Permit Inspections

Permit Number: **SFD2501-0087**

Description: **79x67 4bed 3.5 bath w/deck**

Site Address: **4727 NC 55 E**

Job	Truss	Truss Type	Qty	Ply	
B1124-6094	A2	Hip Girder	1	2	Job Reference (optional)

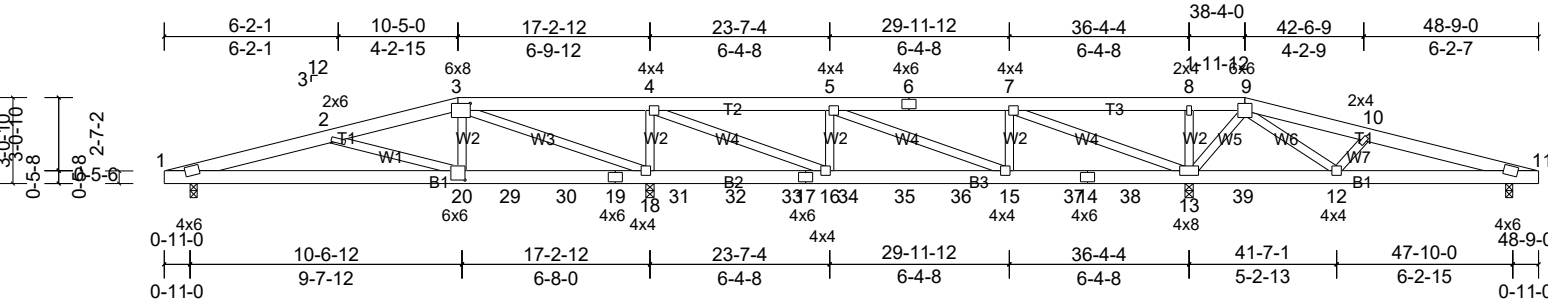
6/11/2025	6/11/2025	ROUGH IN	Steven Gazlay	FAIL W/ PENALTY	eTRAKiT Inspection Request
Notes: 6/10/2025 10:55 AM William (Billy) Elmore All trade rough-in inspections please and I left the approved plans and truss information in the permit box. Also, please check the swing porch slab prep if required. Thanks, Billy Elmore 336-782-6168 Contact Name: William (Billy) Elmore Site Address: 4727 NC 55 E Phone: 3367826168 e-Mail: billy@elmorebuilders.com 1. Missing roof boots.2. Missing 2 inch washers on garage wing wall. 3. Missing portal frame strapping.4. Chase around Plumbing in.5. Need hangers or properly installed ledger strip on stairwell platform joists.6. Pot filler requires a cut off. 7. Missing insulation stops along garage.8. Drywall window installed in incorrect location.9. Rear slider not installed.10. Fire block top of fireplace chase.11. Repair holes in air barriers throughout. 12. Nail multiply trusses per MFG. 13. Need correct nails in trust hangers.14. Strap Gables for uplift where required.15. Missing bracing and standard gable brace on B1GE.16. Missing 2 x 4 blocking at Ridge on first two bays at gable trusses17. Missing support under post at foyer, need to transfer load all the way to dirt.18. Provide engineering on size and span span of angle that is supporting corrugated decking.19. Gas test down.20. Missing hurricane clips on A2 truss.21. Do not insulate.
